27 March 2026

This is a formal Objection to State Significant Development SSD-96505456 – Cammeray Seniors Living 19–23 Rosalind Street, Cammeray NSW 2062

Figure 14 Location of upper level massing

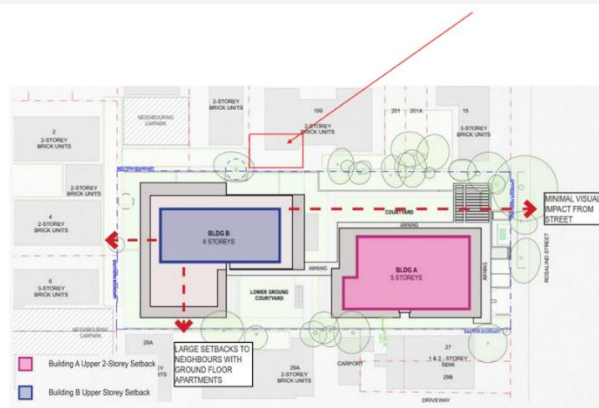
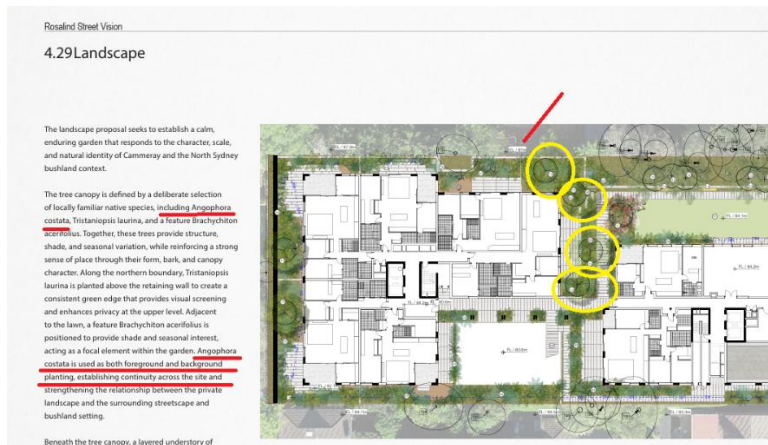
This mitigation has not been applied to my home. In fact, the separation distance proposed (11.5m) is less than the minimum prescribed in the ADG.

- Provide a 15m separation (12 +3m) according to the ADG for transition between zones as we are within a lower density R3 zone,
- I also wish to ensure that privacy devices are deployed to all western and northern windows and decks: Unit BG 01, BG 02, B01, BG02, BG 03, B102, B103 [north], B202, B203 [north], B302, B303 [north], B402, B501

Detail from Appendix B_Design Report p. 25 showing location of T 13 next to 5/199 West Street

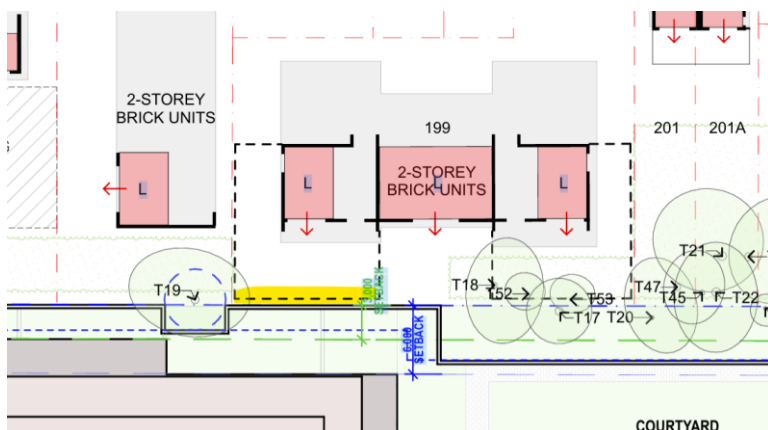
The proposed tree T13 – *Angophora costata*, located within the 6 m setback, is inappropriate due to its excessive height, invasive root system, branch-drop risk, and wide canopy spread. At maturity, this tree will negate the proposed solar access benefits to 199 West Street properties.

- Replace T13 with a tree species of approximately 15 m mature height and smaller canopy spread, planted at least 5 m from the boundary; and
- Increase the western boundary landscaping setback to allow deep-soil planting and layered screening.
